FORD ROAD, ARUNDEL

PLANNING APPLICATION AB/54/22/DOC

SUDS MAINTENANCE STRATEGY COMMENTS

TITLE
**Domestic Drainage Construction
Details Sheet 3 of 4**

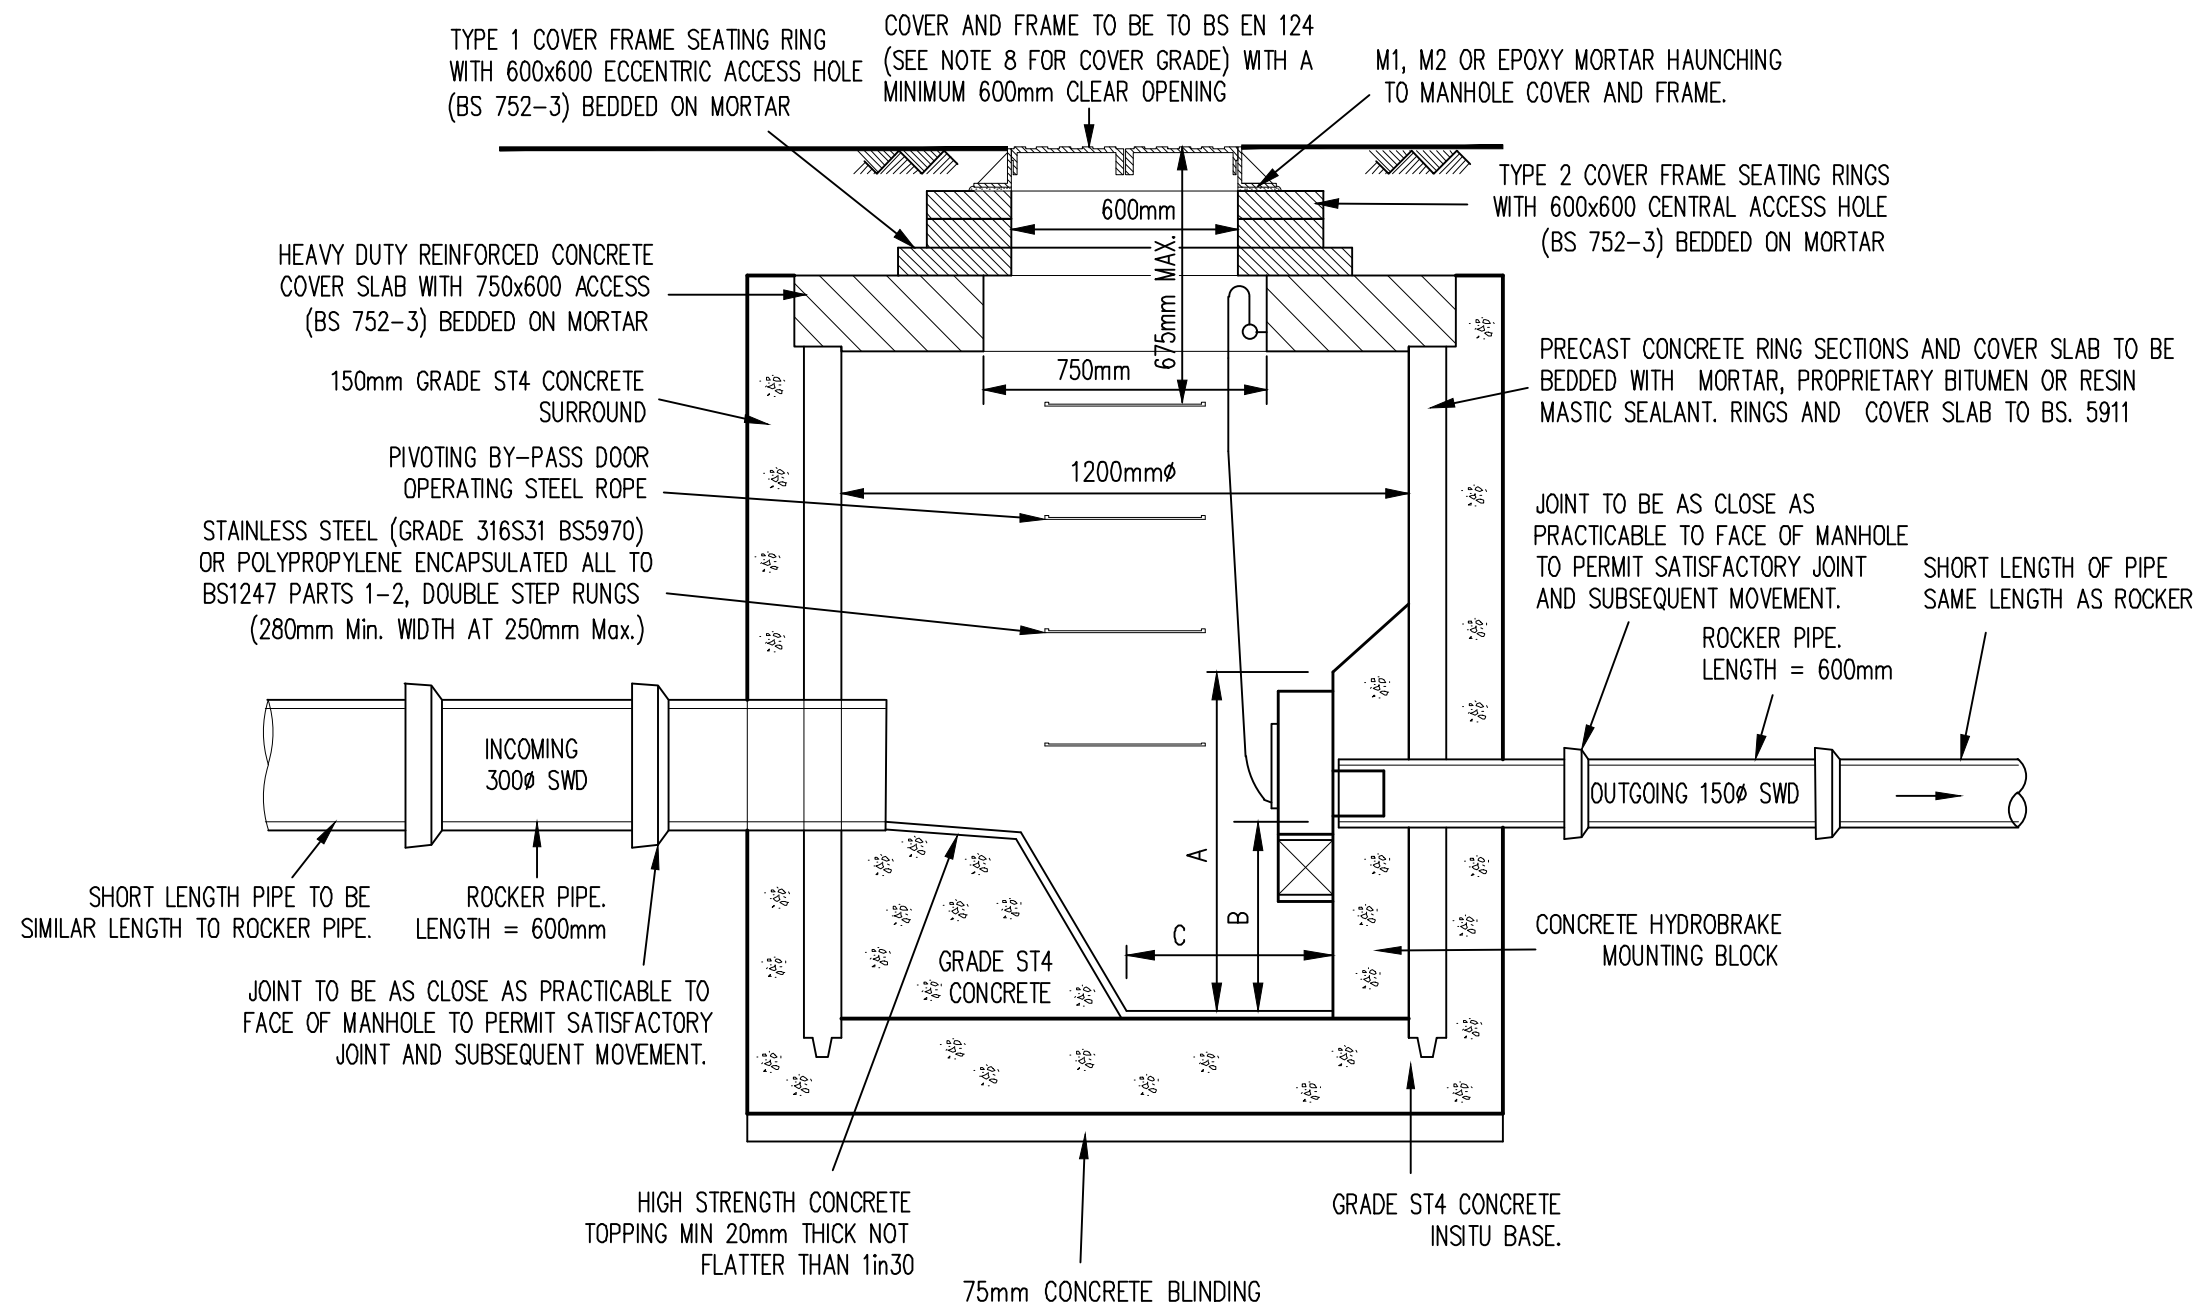
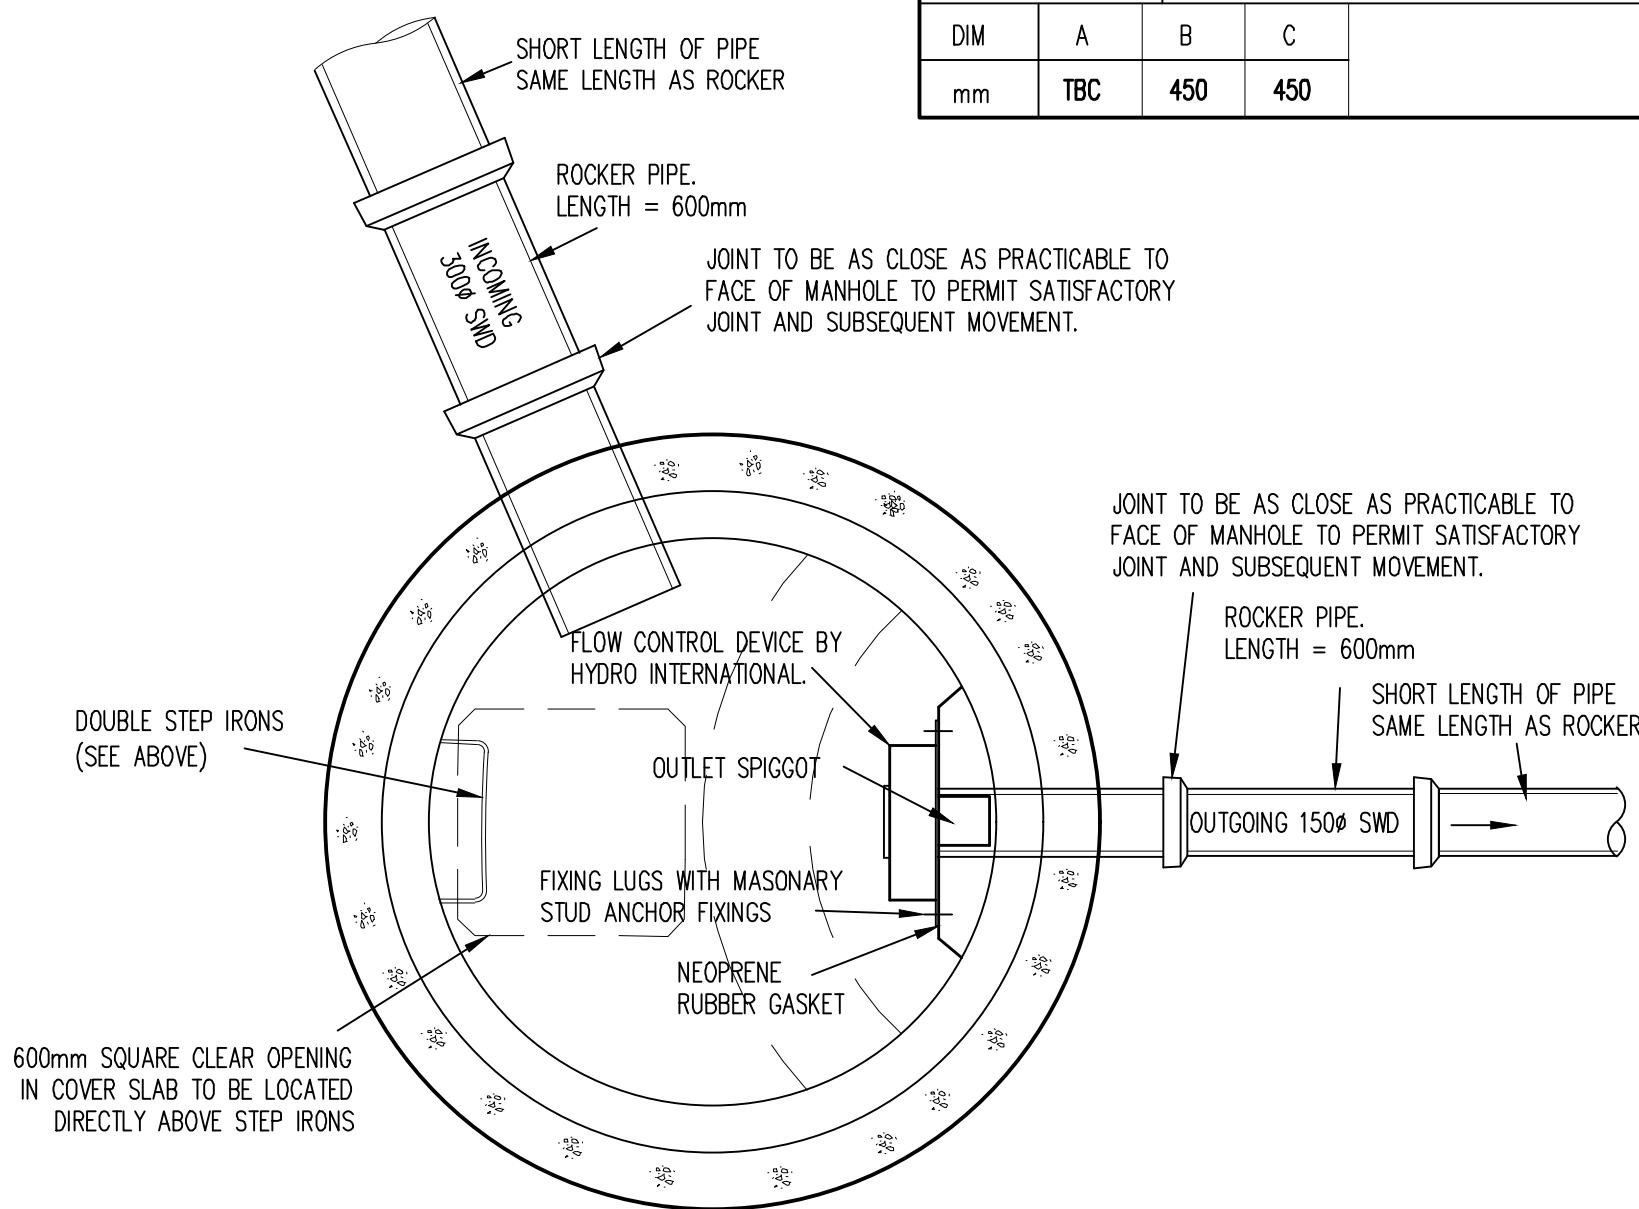
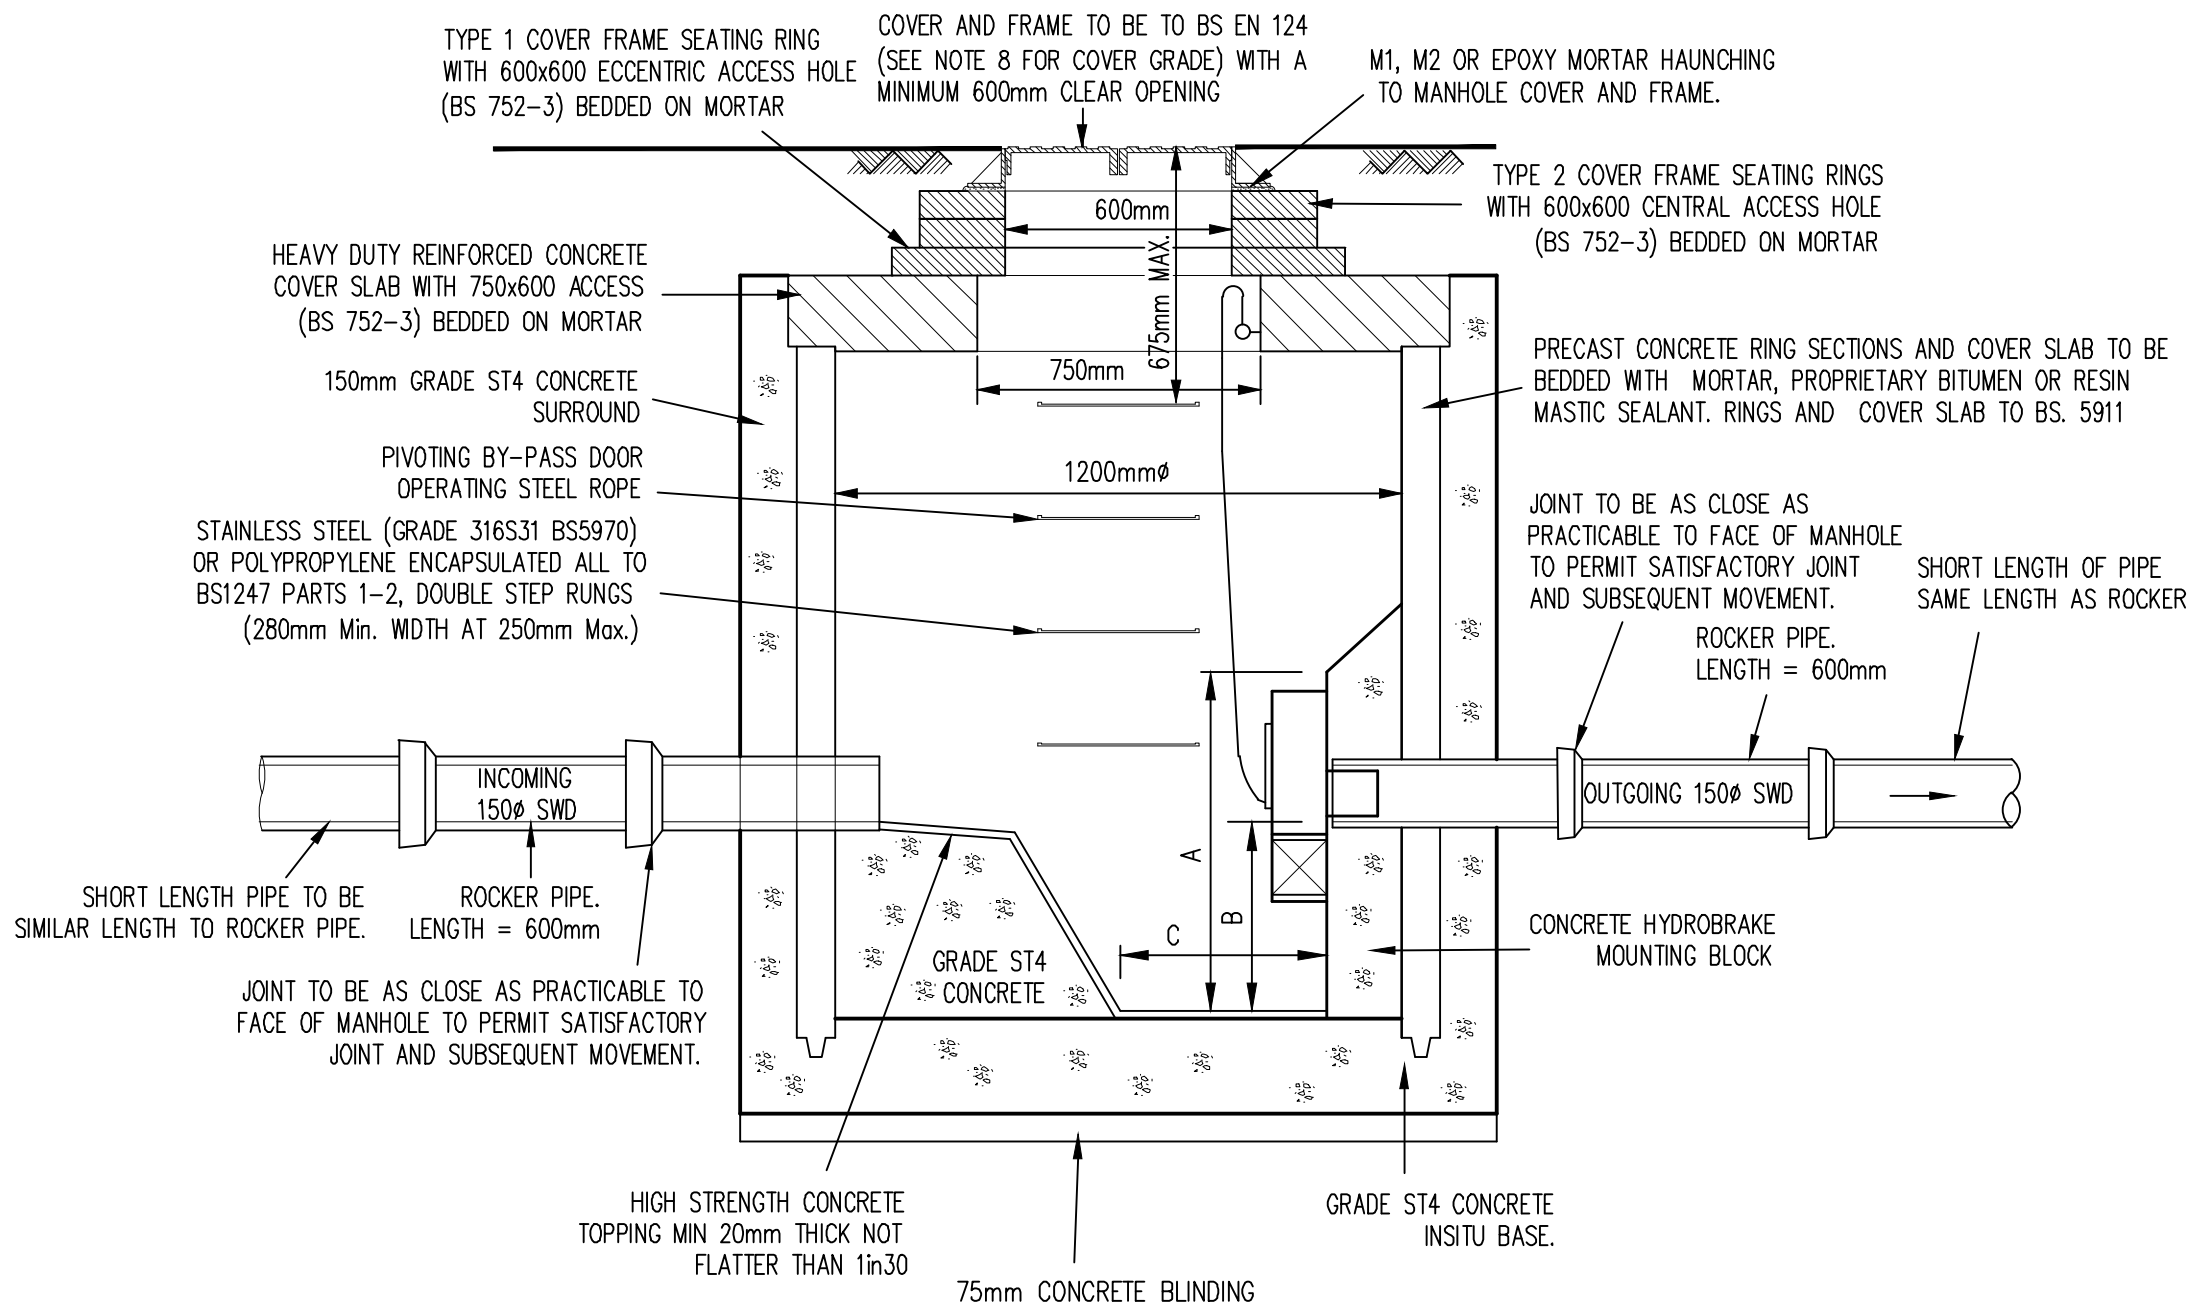
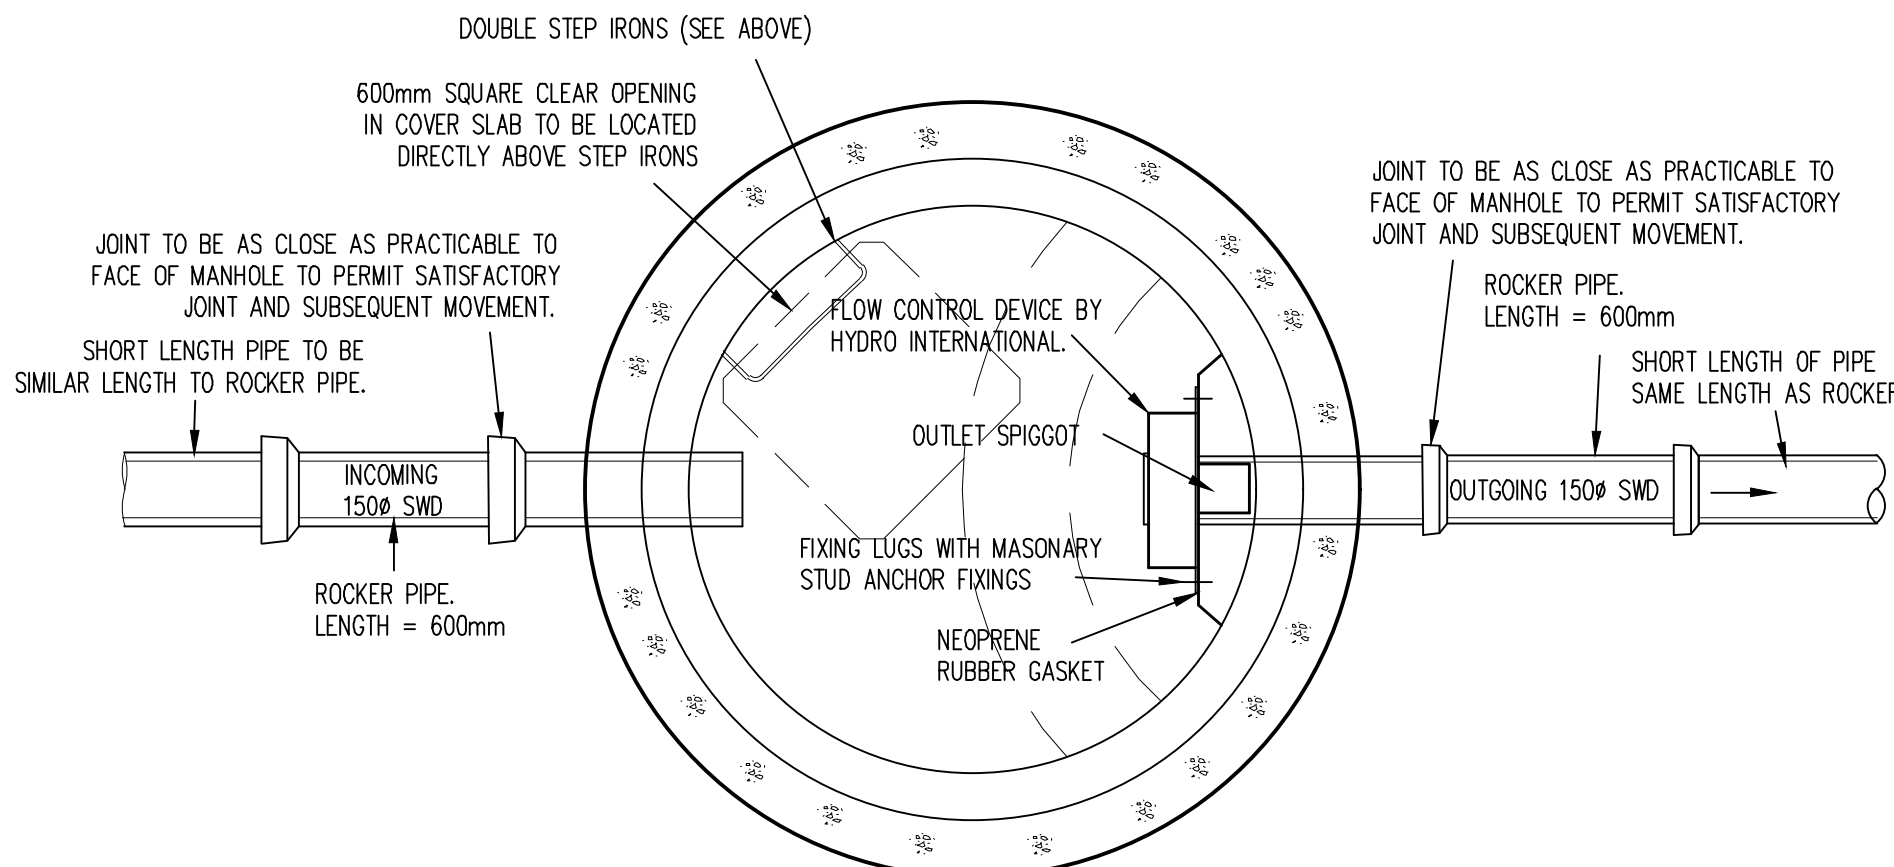
12. Please include maintenance specific to each of the proposed flow control devices, as well as details of the model, make and manufacturer. The flow control maintenance will also need to include detail inspection, greasing and movement of bypass door on any hydro-brakes and the frequency of this.

Details of the individual hydrobrakes will be in the O & M manual, a copy of which will be left with the maintenance company.
